DARLINGTON POINT

Review of FBA Assessment

November 2018

Report No. 4689/R01/V3/FINAL

**31 October 2018**

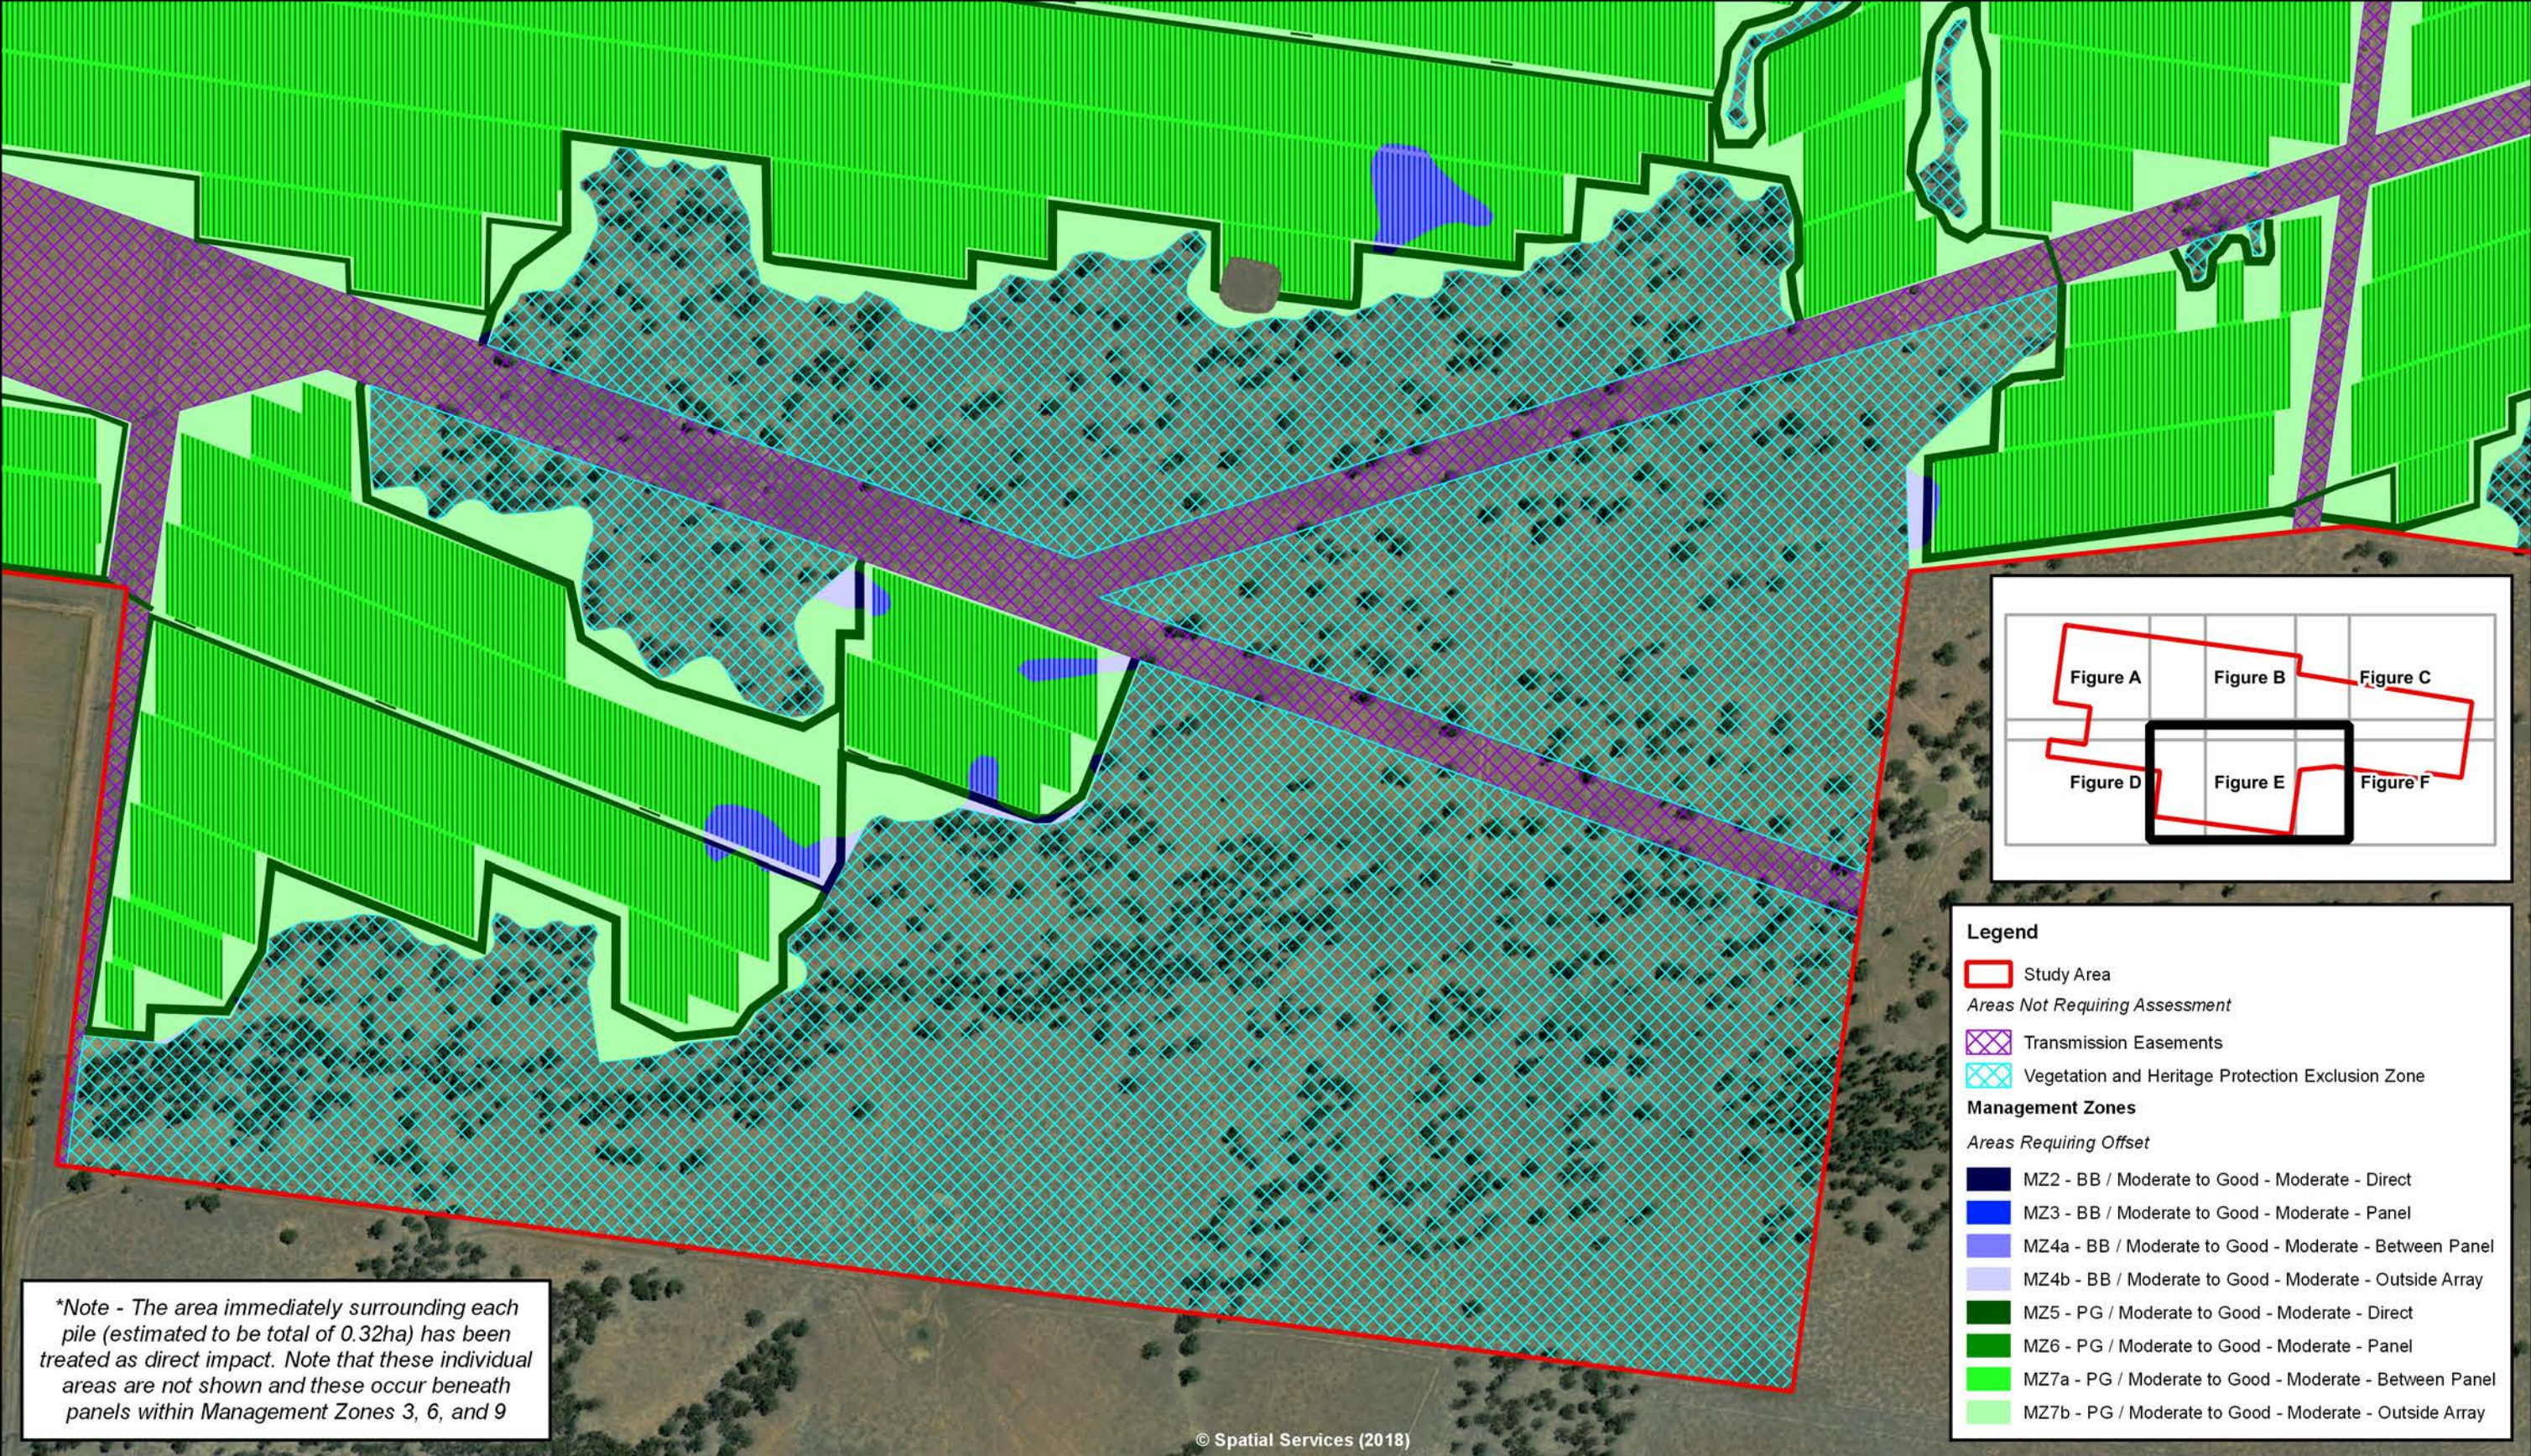
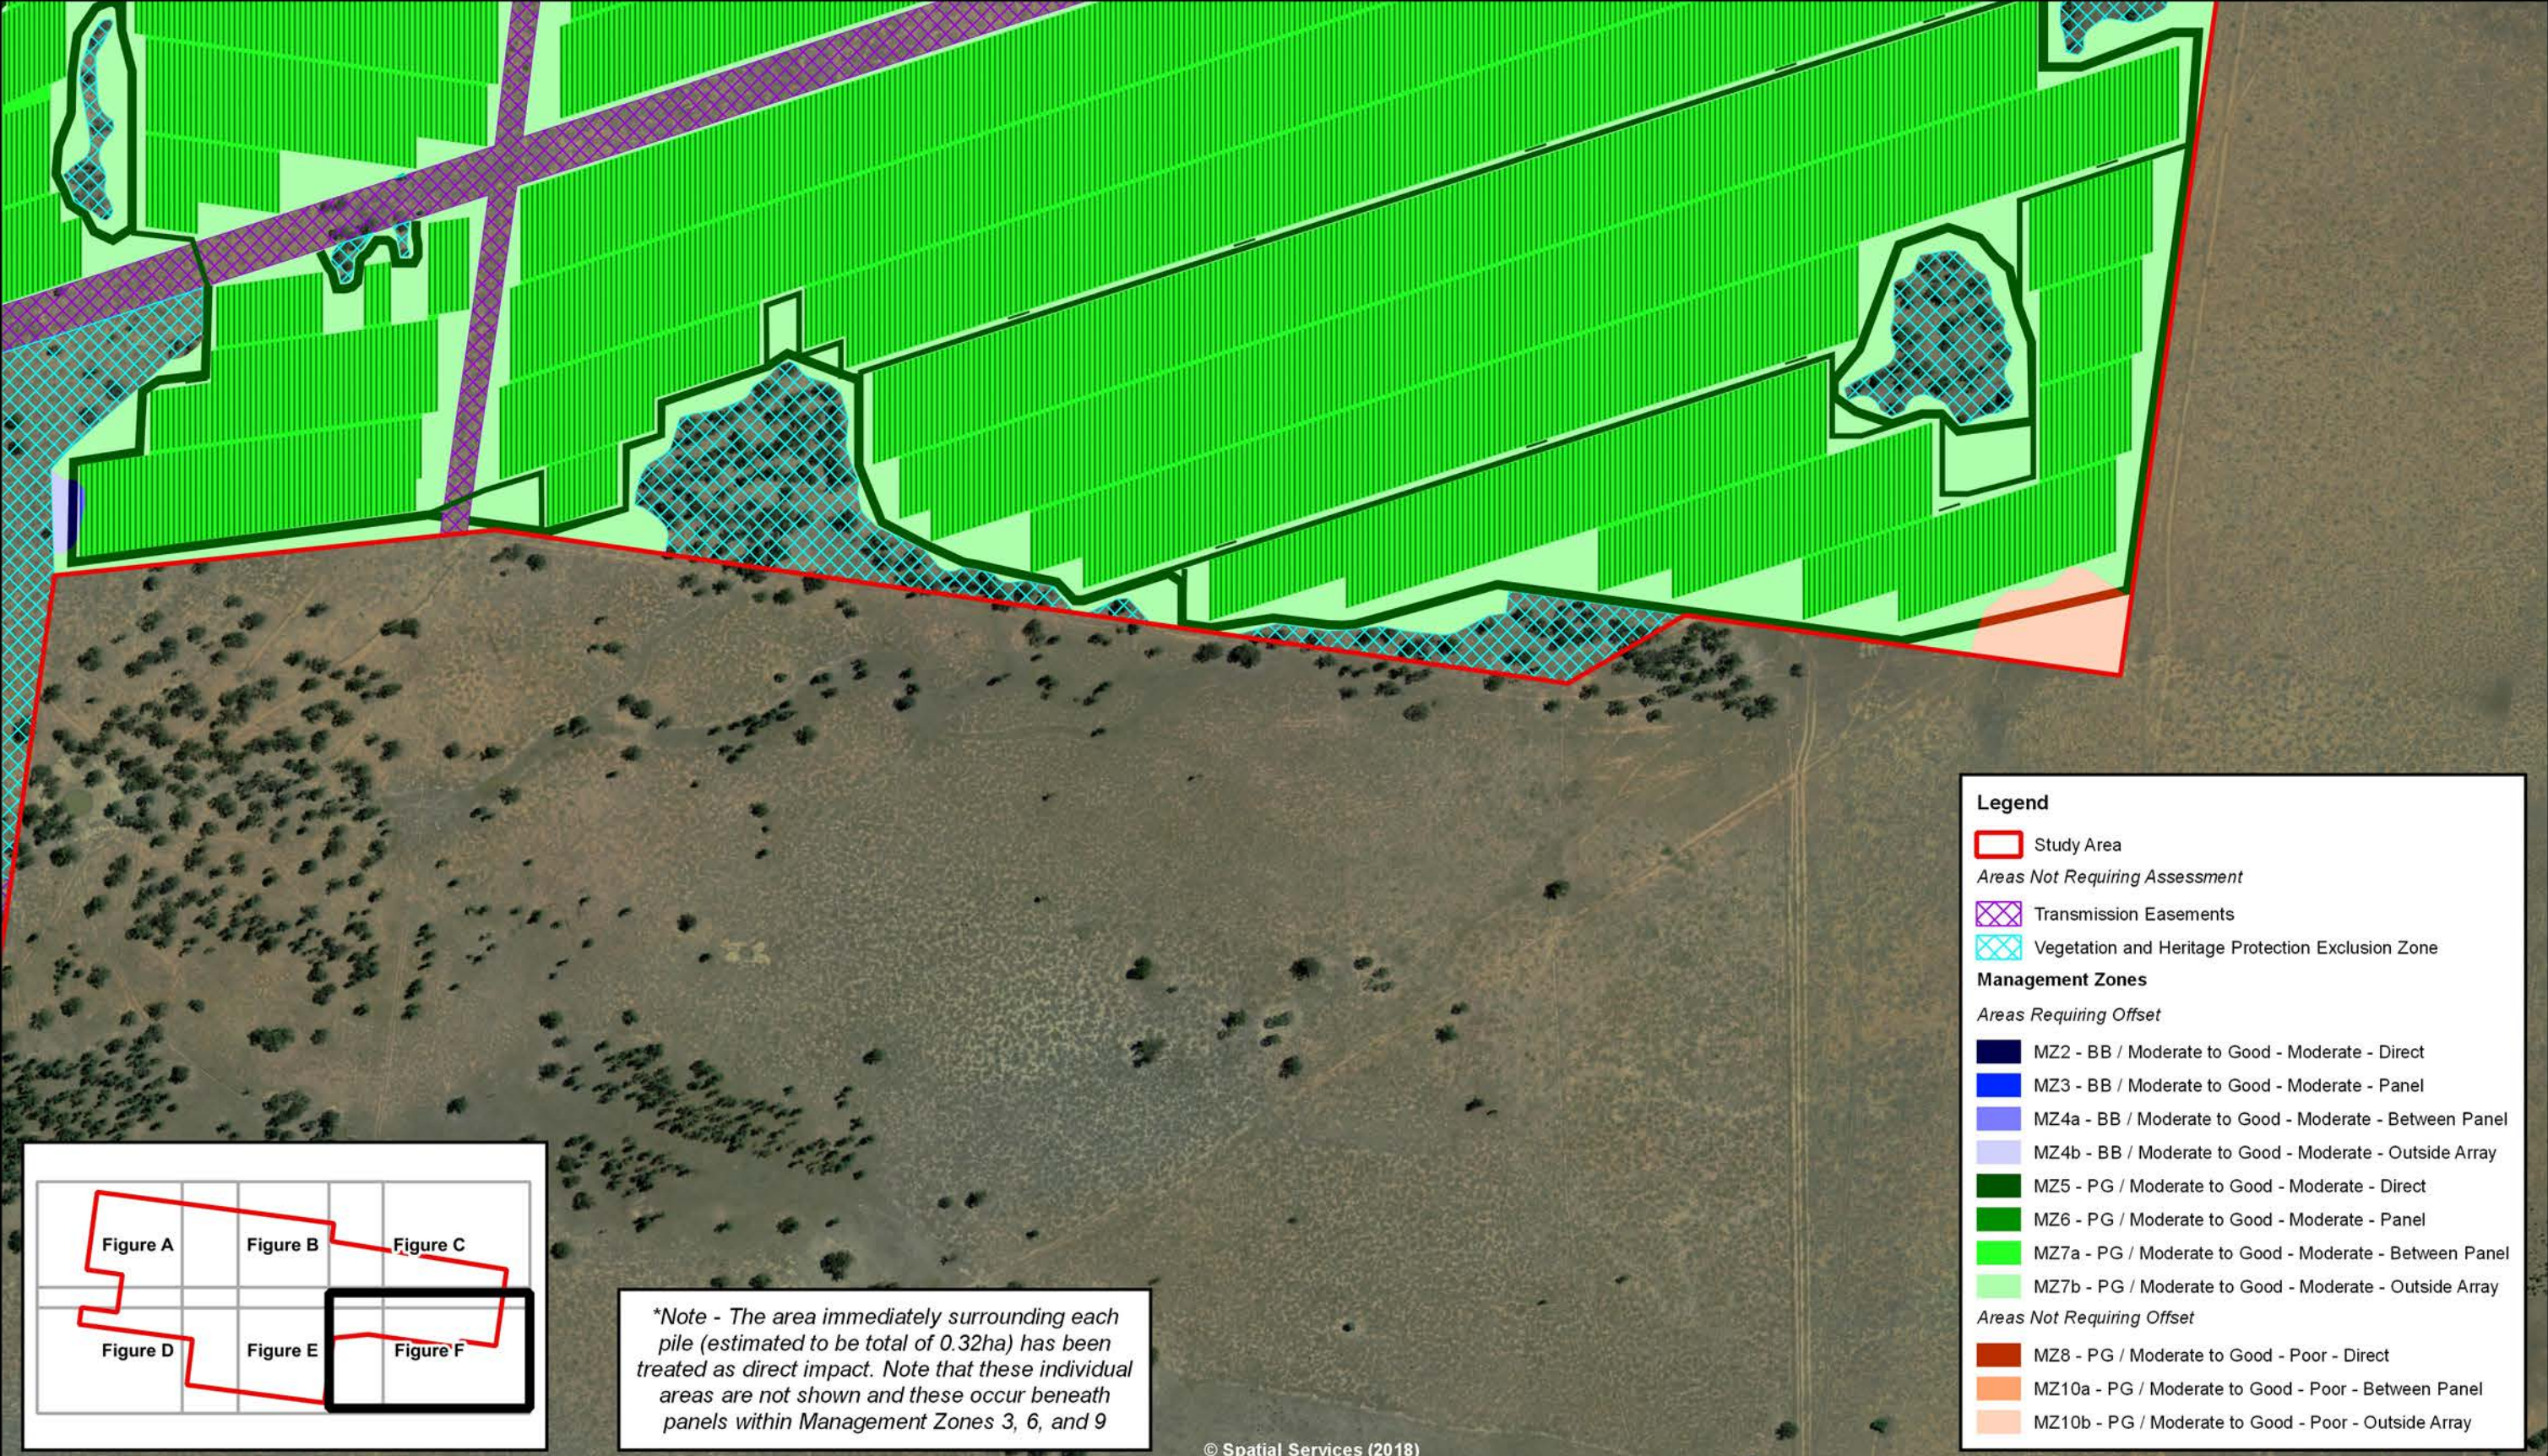
- B. The ‘Non-panel’ assessment zone is confusing because it includes grassland ‘between panel rows’ and ‘outside array’. These areas have different potential impacts. A map of management zones, in accordance with standard FBA methodology, would assist in understanding how biometric site score values have been apportioned [this is a reasonable request].

1. **The proponent should provide a map of management zones and indication of how future site score values have been apportioned across vegetation zones.**
